1865 WOODMOOR DRIVE

LANDSCAPE PLAN

PPR1830

LANDSCAPE PLAN NOTES & DETAILS

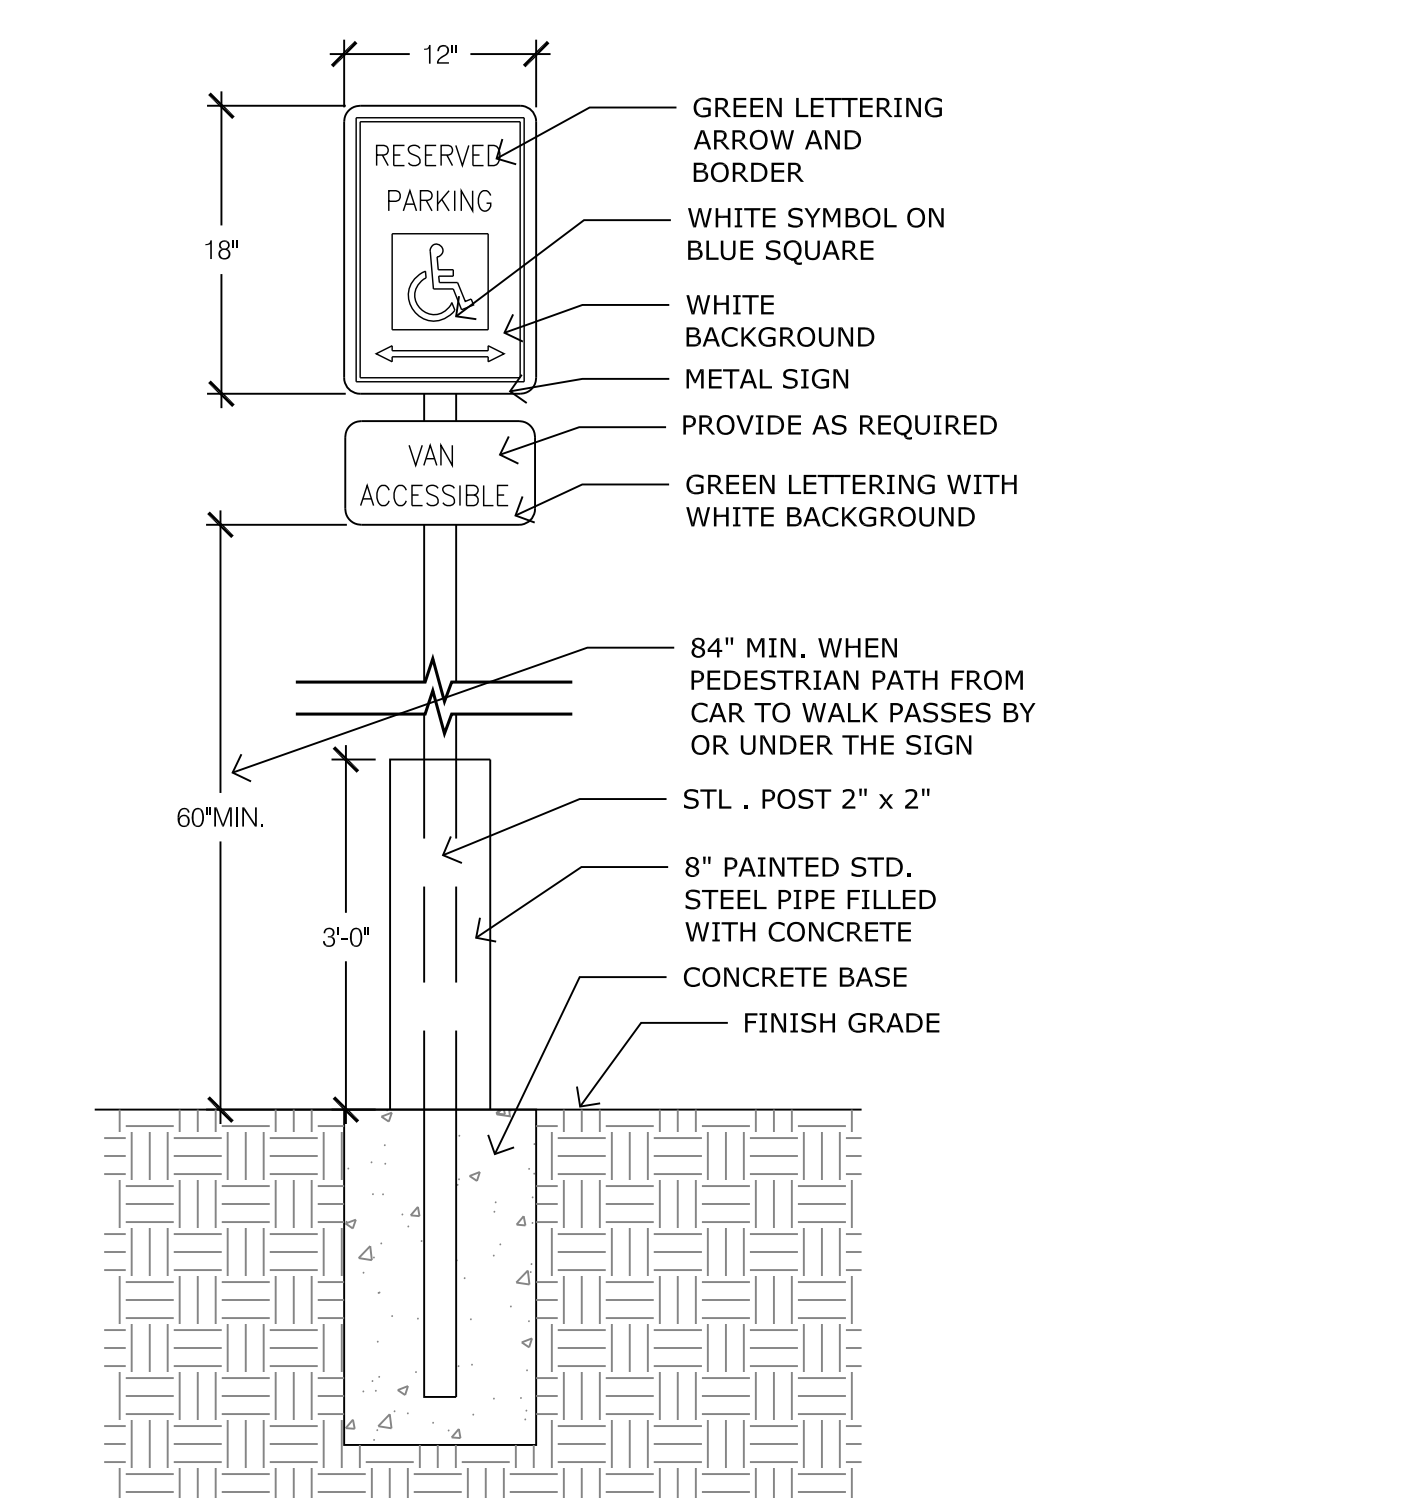
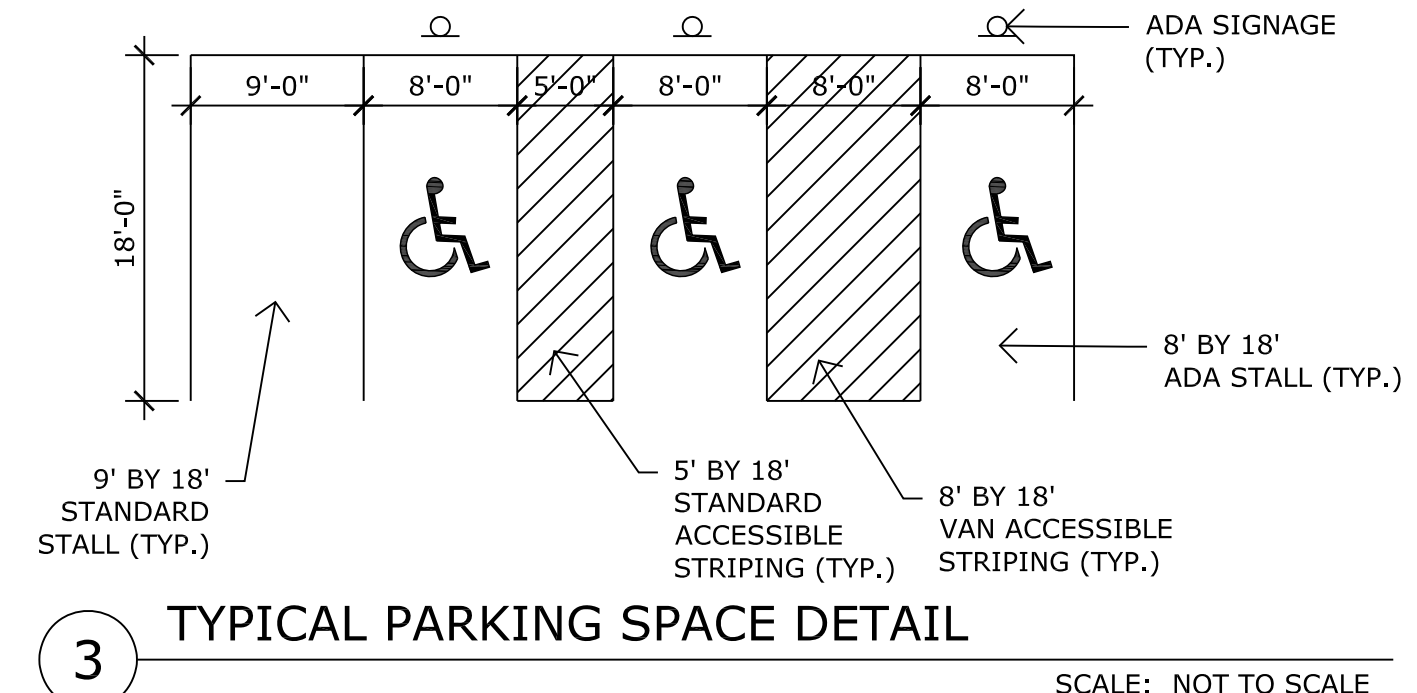
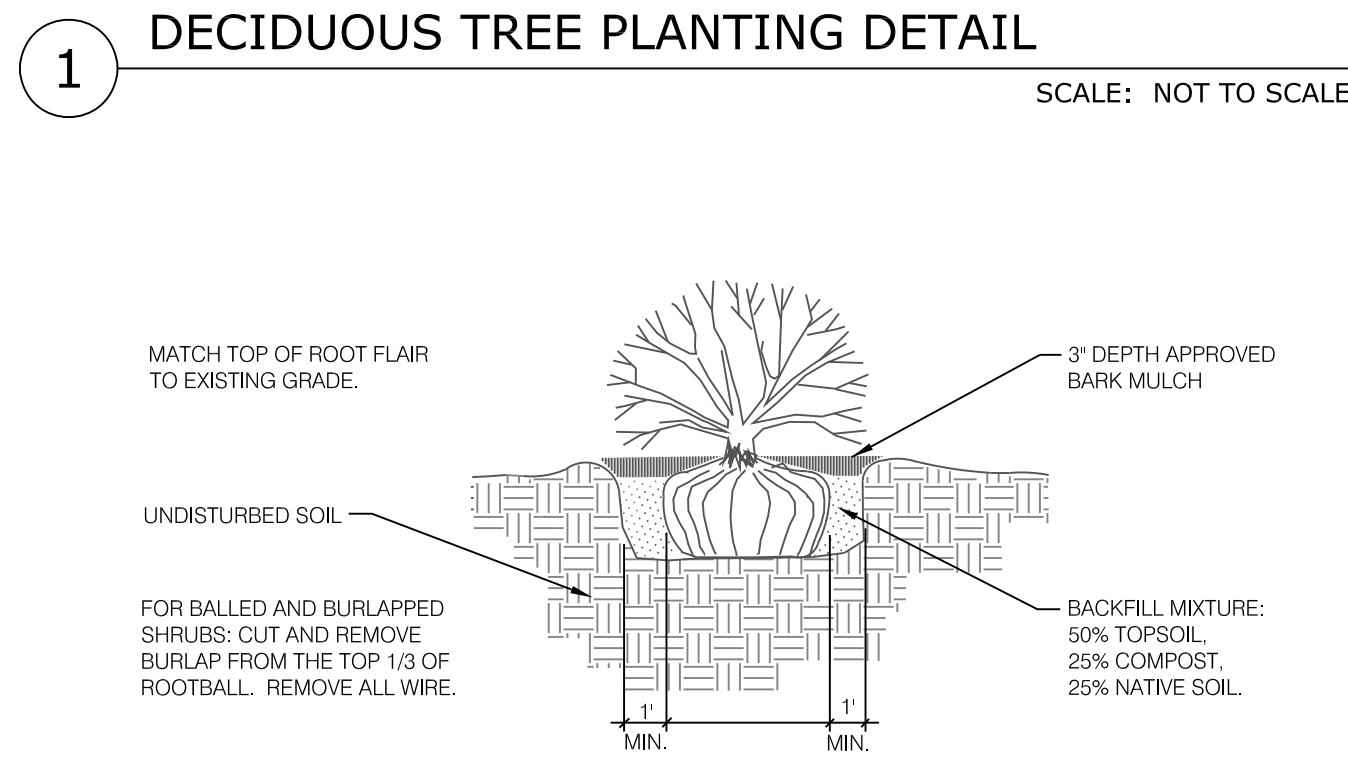
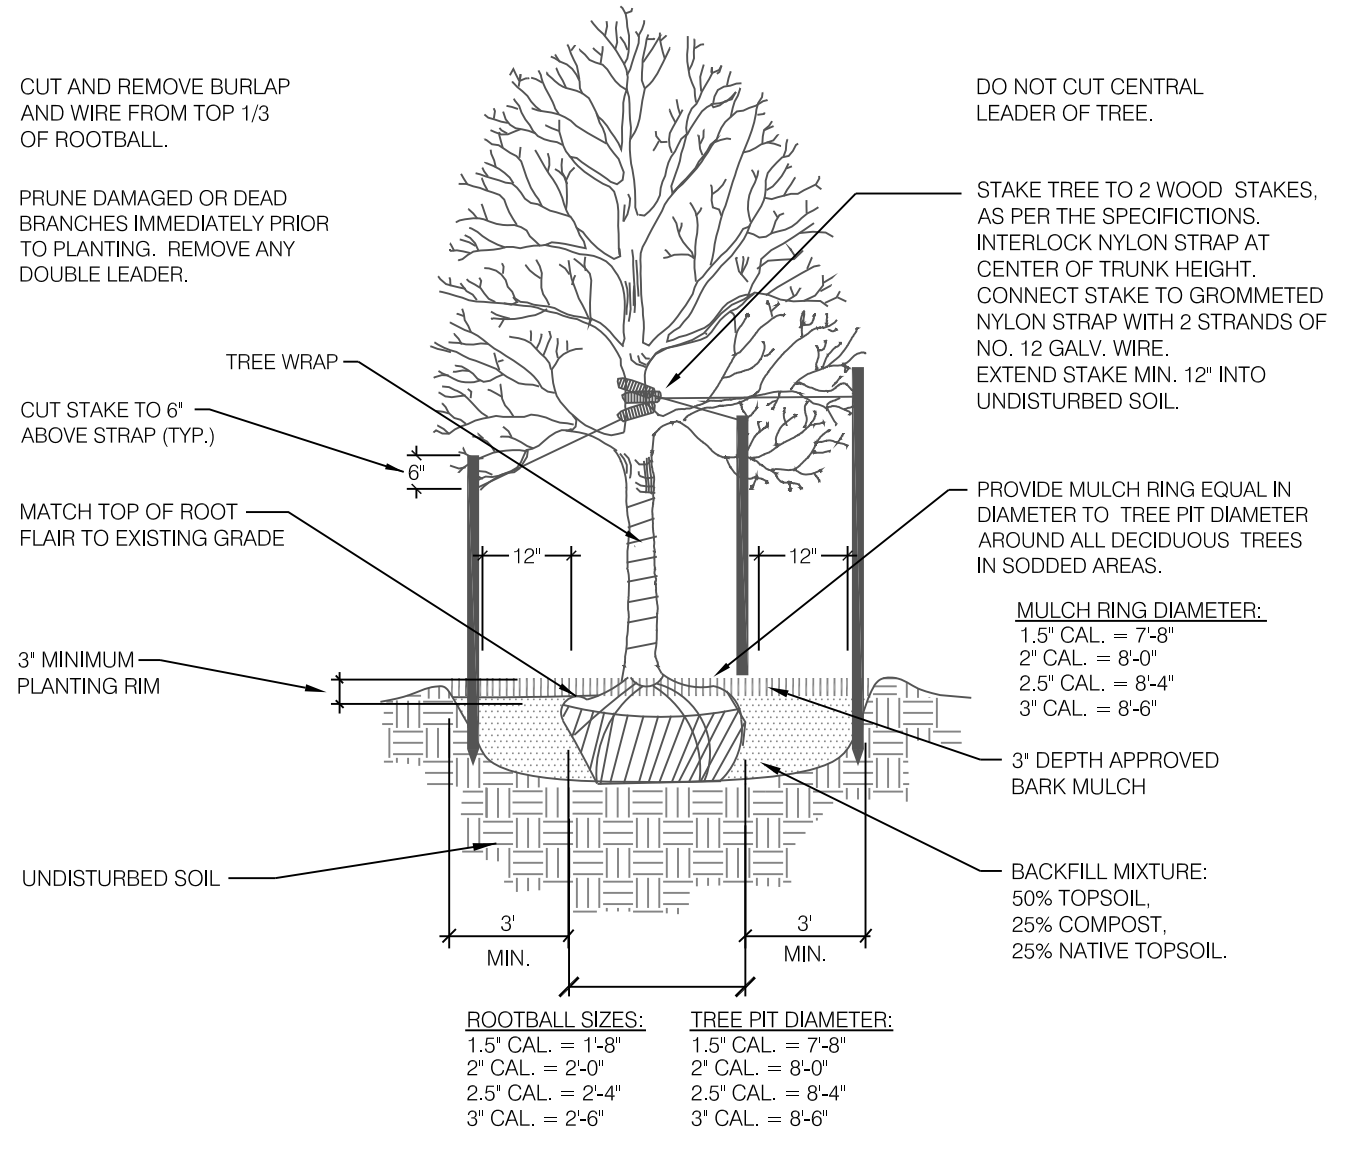
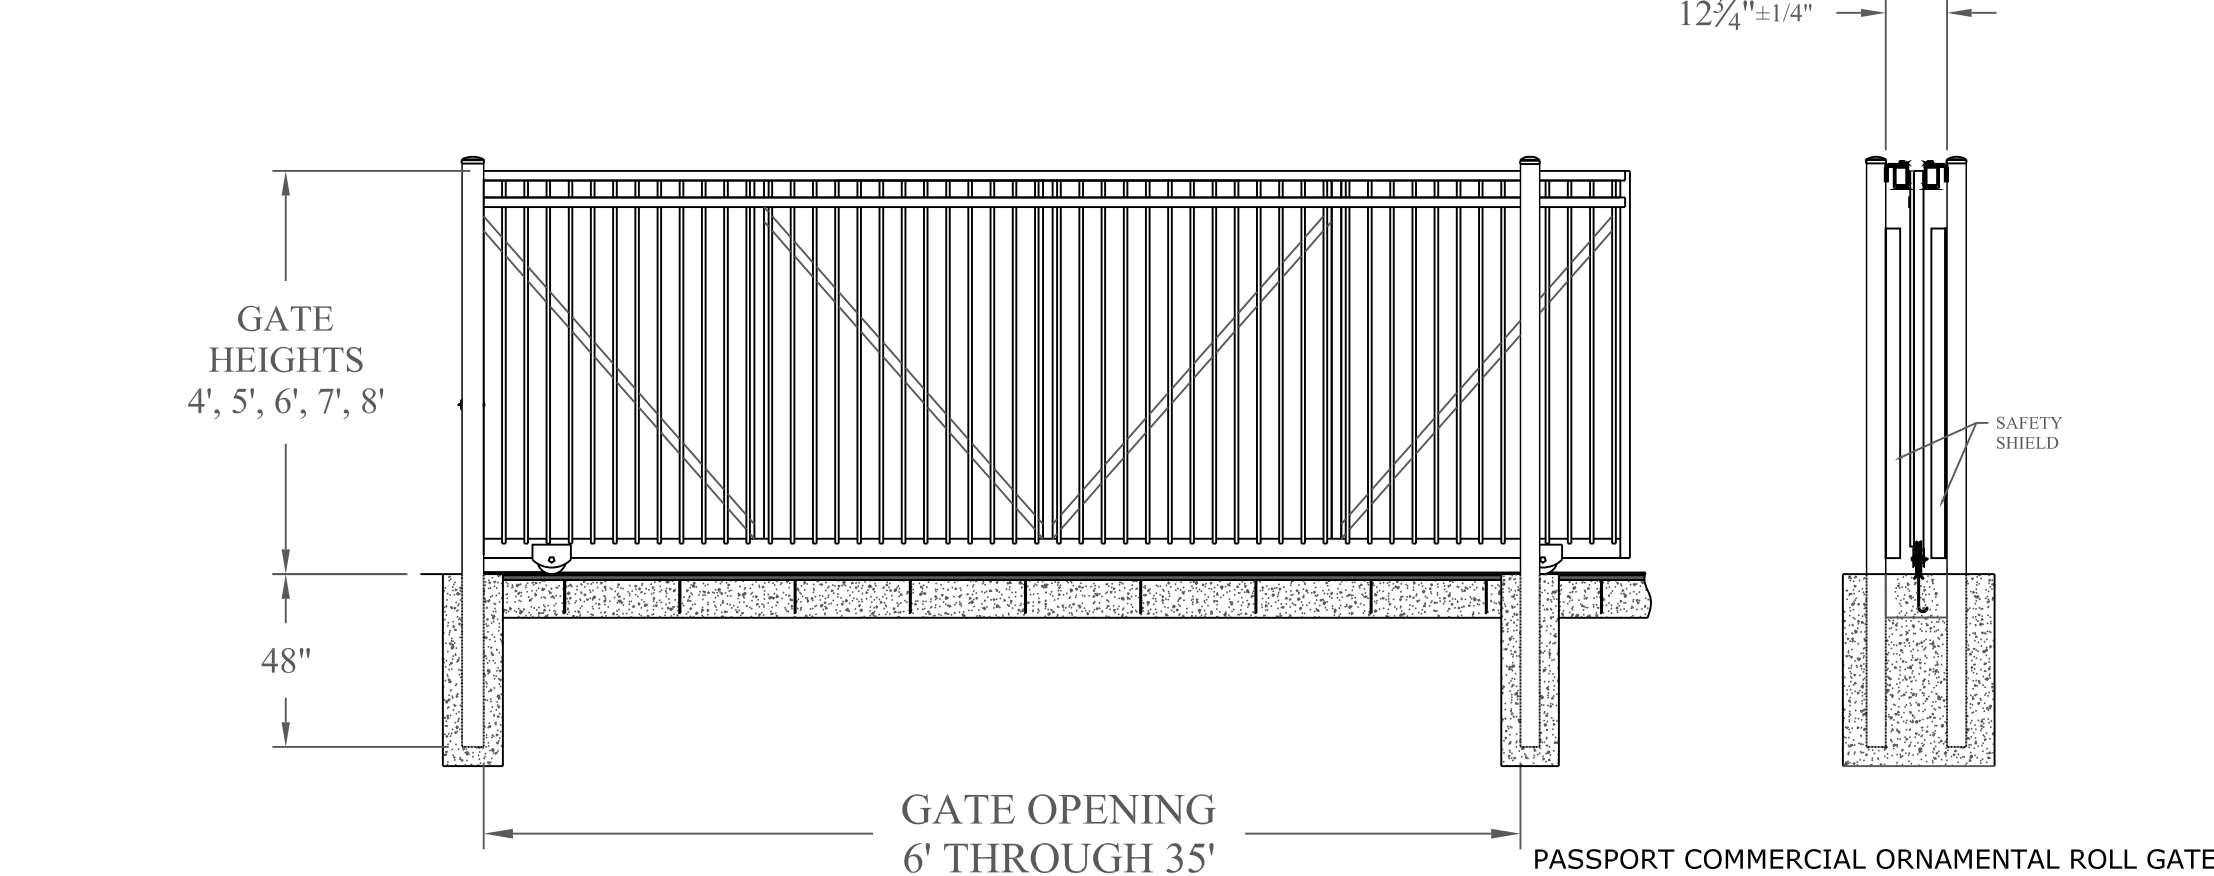
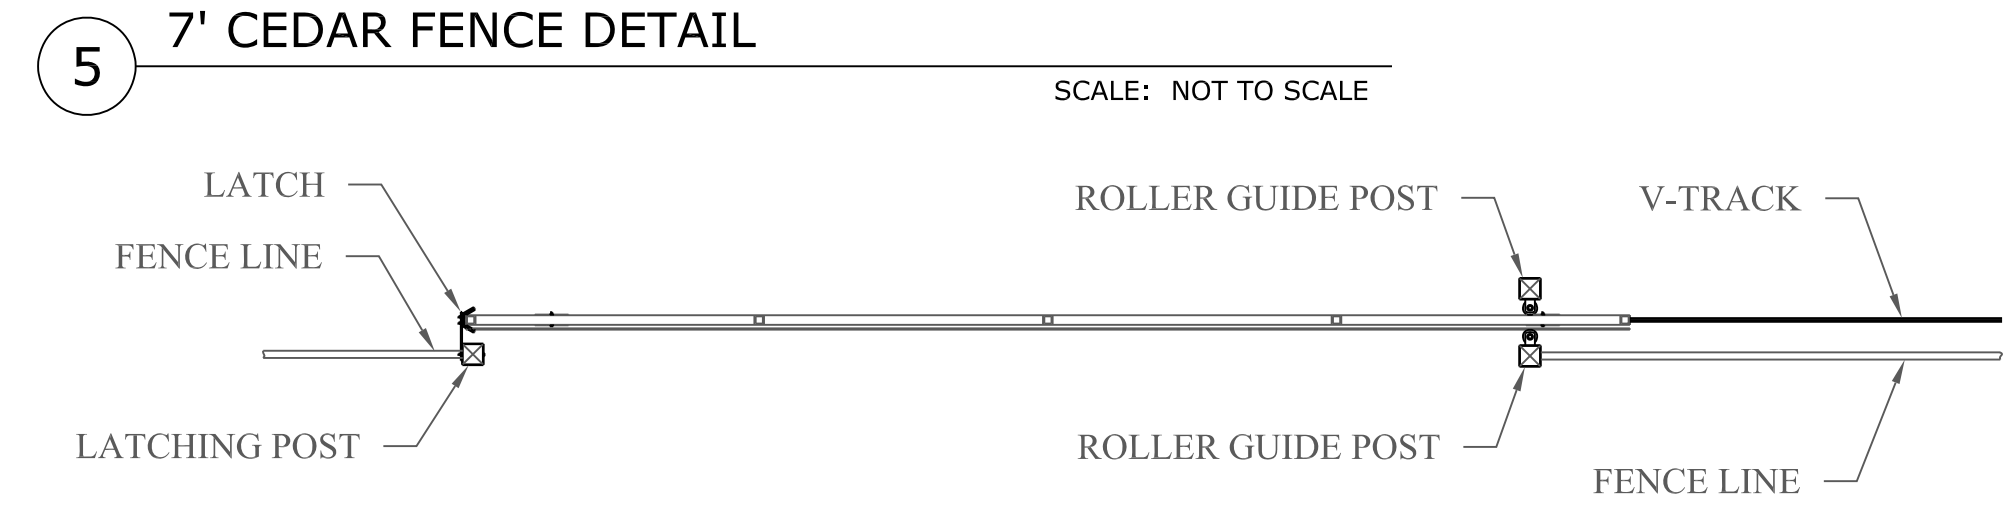
There is no height shown on the details page 2 to indicate if the shrubs meet the 3' LDC requirement outlined in the Chapter 6 overview provided. Please add a height so that we may confirm compliance.

Please provide a side elevation of the trash enclosure.
